Simon Truong - MP06_0037 MOD 4

Proposed modification to marine refuelling and supply facility to allow for dry boat storage (MP06_0037 MOD 4)

Drawing Title
 PROPOSED SITE PLAN

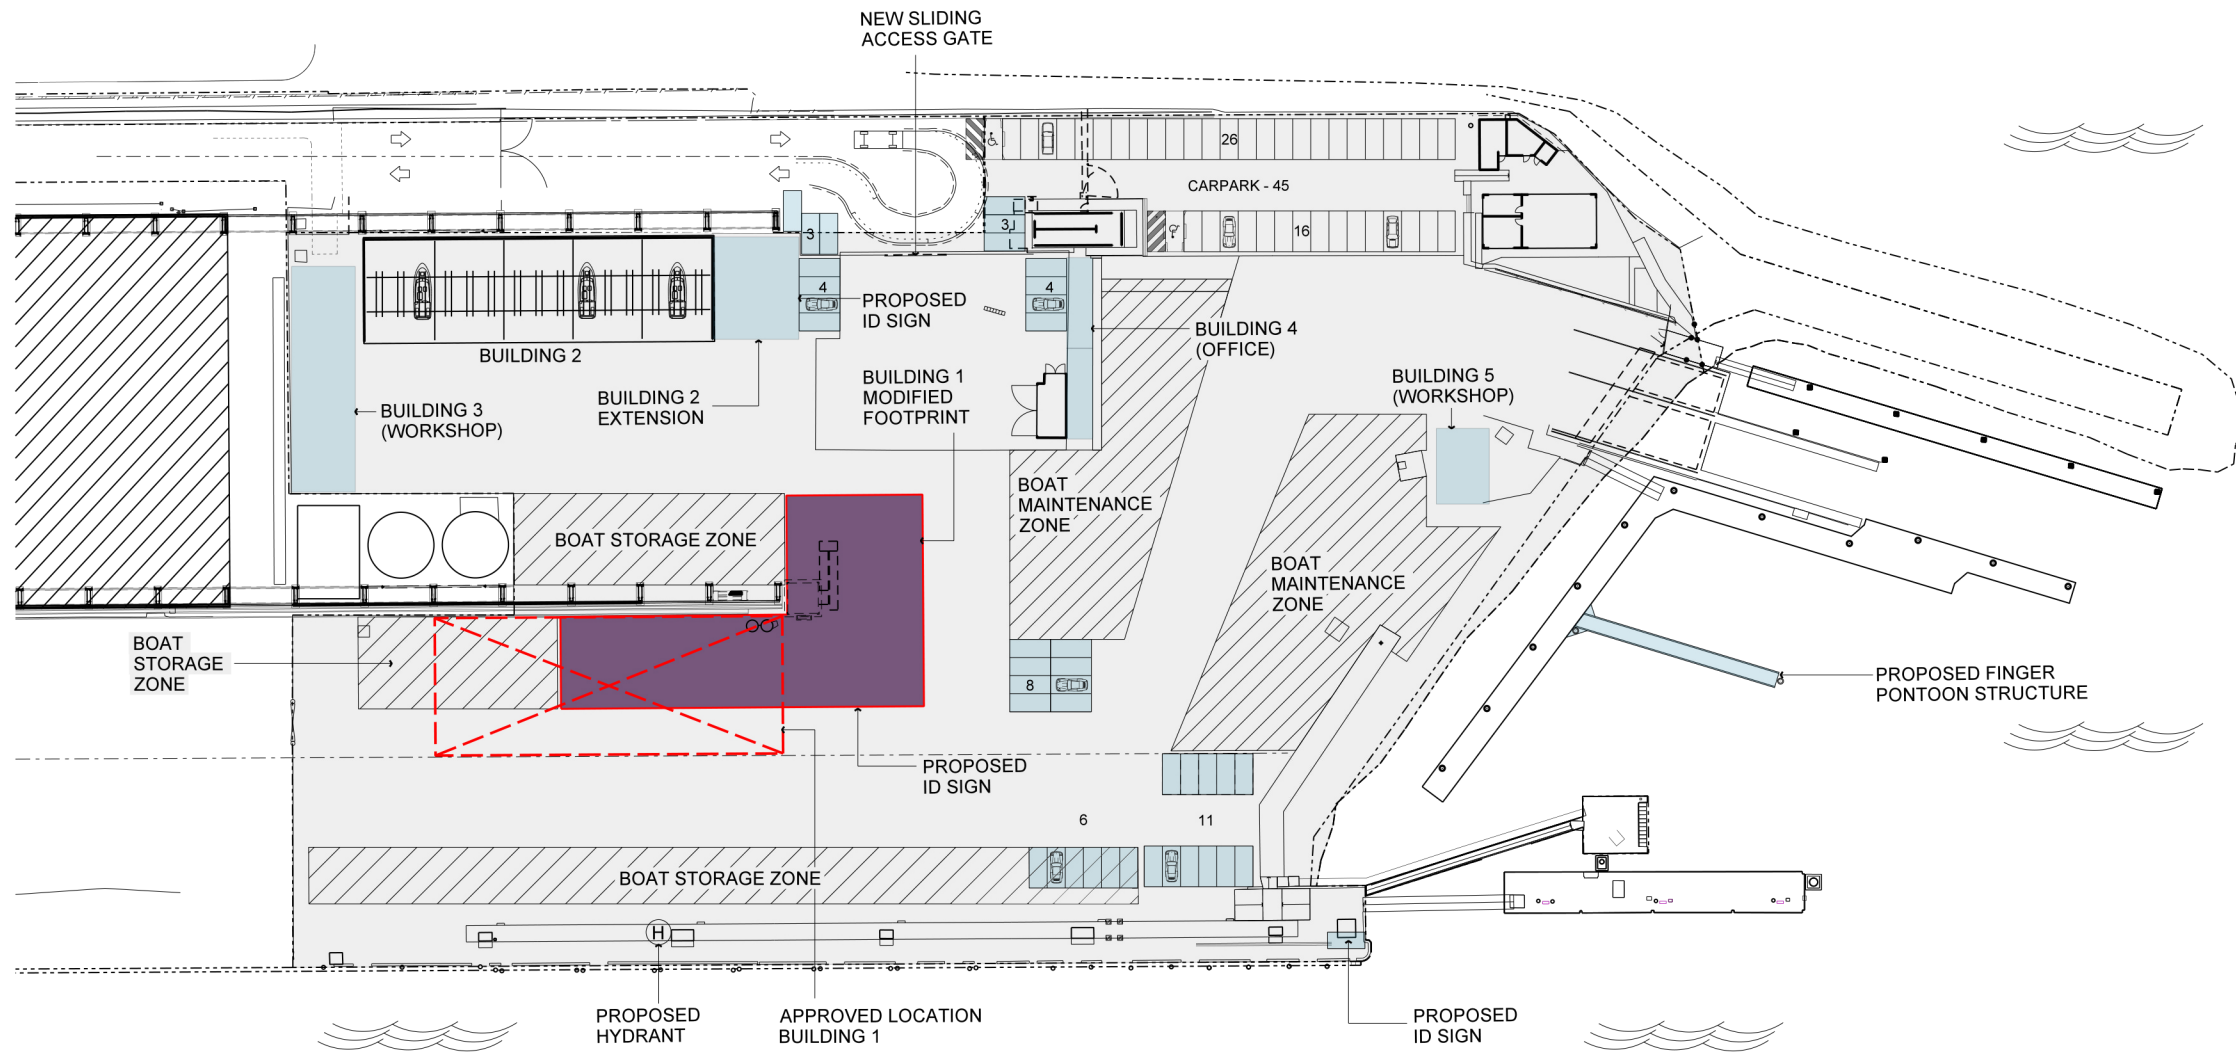
The two primary environmental impacts, apart from navigation safety, relate to traffic and the introduction of a new building at the point.

There is little justification for a "meet and greet" building on the hardstand in the context of existing approvals for two large scale building which include provision for offices, workshops and showrooms. A new building on the point should be avoided particularly in the context of long term community desire for the headland to be turned into public green space.
